Reference No:	2025/44/93104/W
Site Address:	The Ukrainian Club, 7, Edgerton Road, Edgerton, Huddersfield, HD1 5RA
Description:	Discharge of details reserved by conditions 3 (windows), 4 (floor covering) on previous permission 2023/92123 for Listed Building Consent for conversion of existing garage into games room and associated alterations (within a Conservation Area)
Recommending Officer:	Joshua Merriman

DECISION – APPROVE DISCHARGE OF CONDITIONS

DISCHARGE OF CONDITIONS

External Door Elevation - As
Proposed (DRAFT)

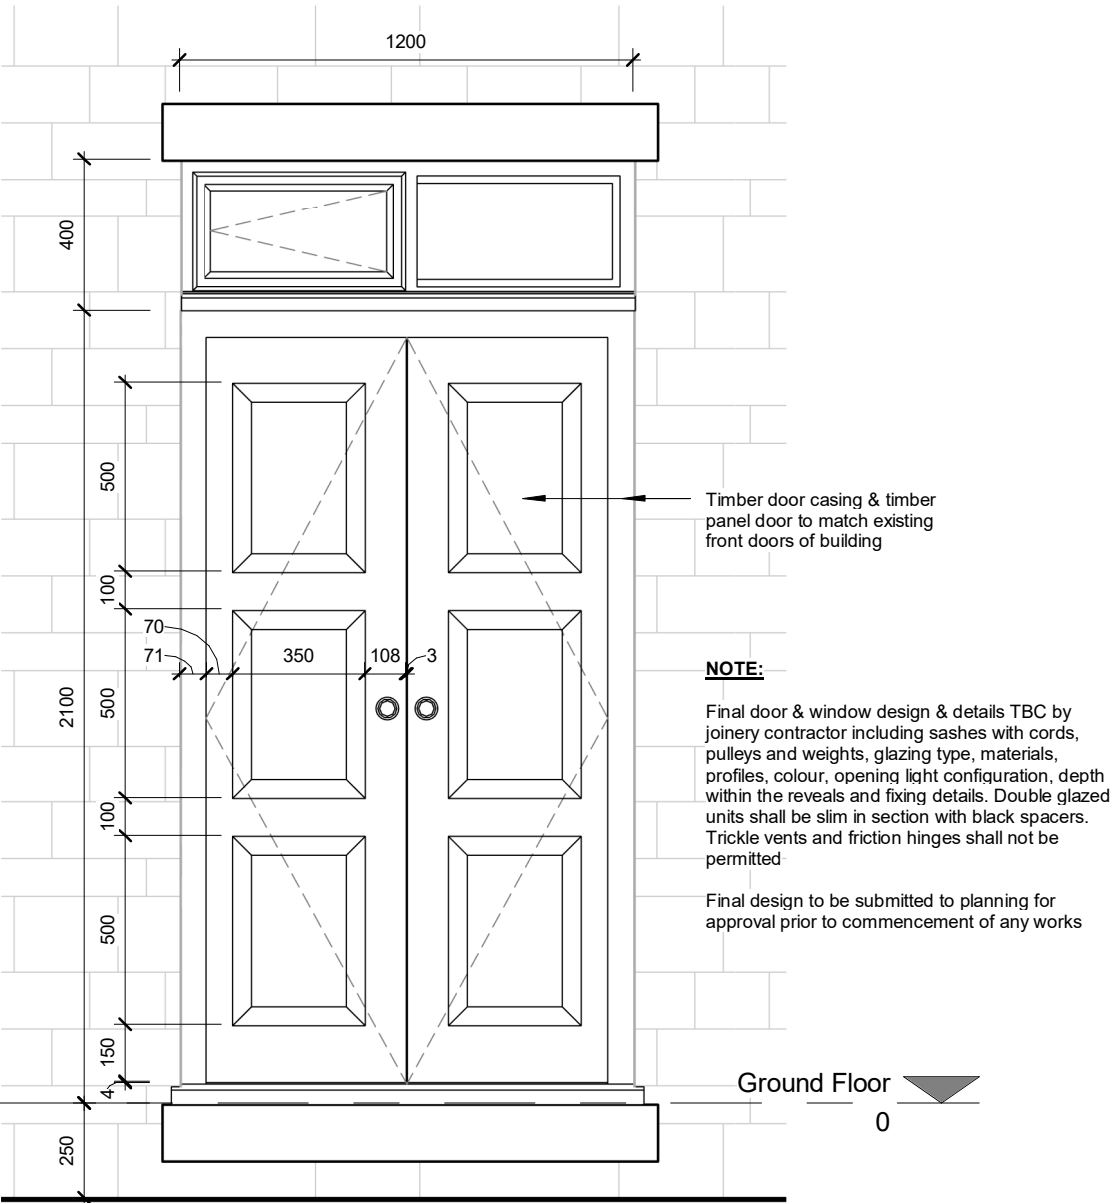
Following an informal consultation with KC Conservation & Design, the window and door details submitted were considered acceptable and in accordance with Condition 3 from previous permission 2023/92123.

It has been confirmed with the applicant that the windows and doors are to be timber in material for the avoidance of doubt, which is the preferred material and thus acceptable.

It is therefore concluded that the scheme submitted for Condition 3 is acceptable, and this condition will be discharged by the completion of the development in accordance with the approved details, and their retention thereafter.
